**Recommendation Report for Planning Permission**

**REF NO:** P/28/13/

**LOCATION:** 14 Churchill Walk  
The Parade  
Pagham

**PROPOSAL:** Dwelling house and parking space (resubmission following P/33/12/)

CONCRETE SLATES

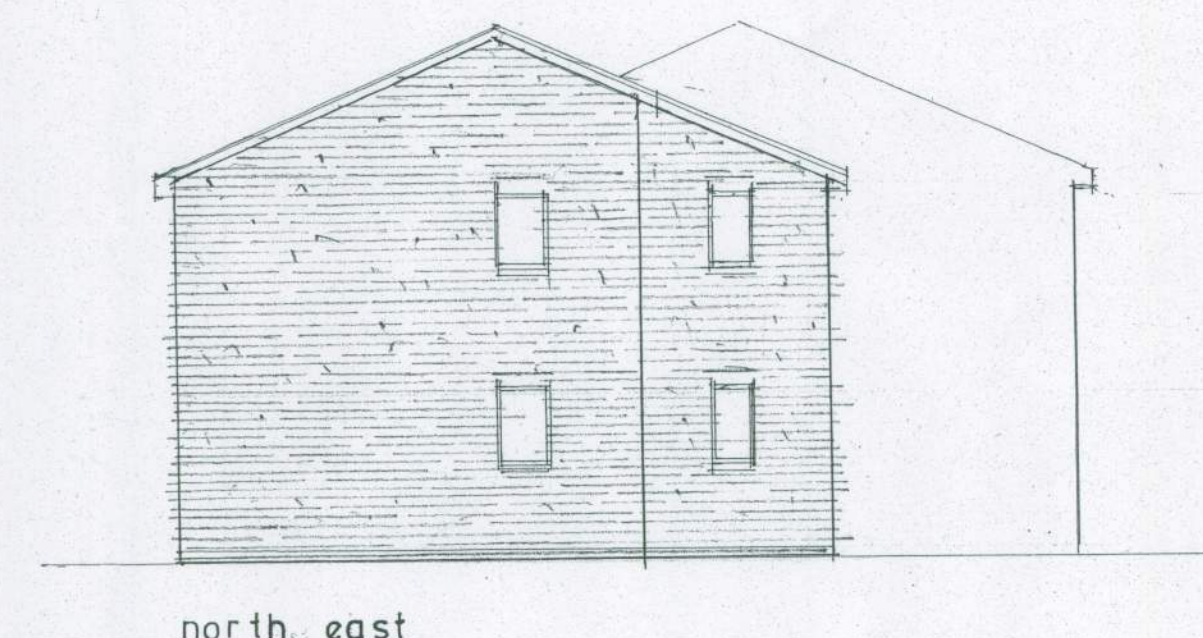
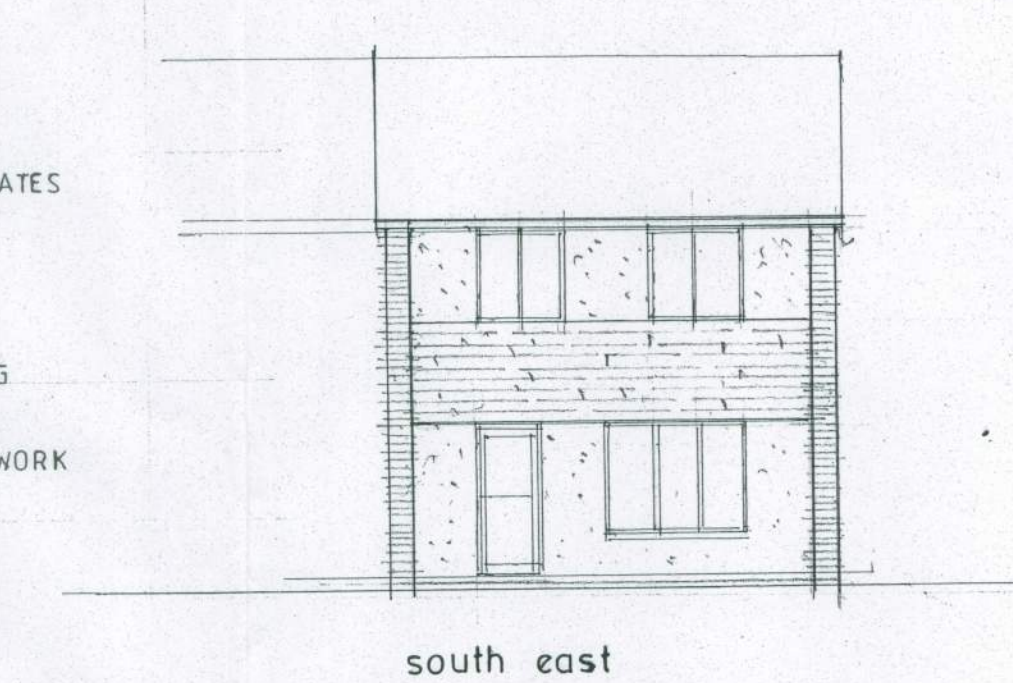
The proposal is considered to conflict with relevant Development Plan policies in that by reason of its siting and cramped space it does not contribute to the open and planned characteristics of the surrounding area. It would also give rise to a loss of outlook and daylight to the neighbouring property No 14.

The proposal now seeks to demolish the existing garage currently serving No 14 Churchill Walk and incorporate this space into the site with the construction of an attached two storey dwelling on the end of No 14 in the side garden. A new parking space will be provided at the front of the host dwelling No 14. The proposed dwelling will be set back from the front of the dwelling by approximately 3m and will at its lowest point leave a 1.1m gap to the public footway. It will be of the same height as the existing terrace and similar in appearance. By reason of its siting the proposed dwelling will project out from the host dwelling No 14 to the rear by 3m. No 14 has windows which serve the living area adjacent to the side flank wall of the dwelling and it is considered that this would seriously affect the occupants outlook and daylight.

The National Planning Policy Framework Paragraphs 56 and 57 specify good design that would achieve development that is better integrated with its surroundings. The plot is still considered to be of a size that would not easily accommodate a dwelling of this size and would afford a poor standard of amenity and outlook for future occupiers. It would erode the open spacious character and appearance of the area which is a feature of the 1960's estate.

It is considered that the proposed development by reason of its prominent siting would appear incongruous in the street scene and harm the open and spacious character of the area.

- 1 The proposal is sited within an inadequately sized plot which is uncharacteristically small to accommodate a dwelling and would appear as a cramped form of development which is harmful to the open and planned characteristics of the surrounding area in conflict with policy GEN7 of the Arun District Local Plan and the National Planning Policy Framework.
- 2 The proposal by reason of its siting and relationship with the neighbouring dwelling (No 14) would be overbearing and unneighbourly giving rise to a loss of outlook and daylight in conflict with policy GEN7 of the Arun District Local Plan, the National Planning Policy Framework and the Pagham Village Design Statement.
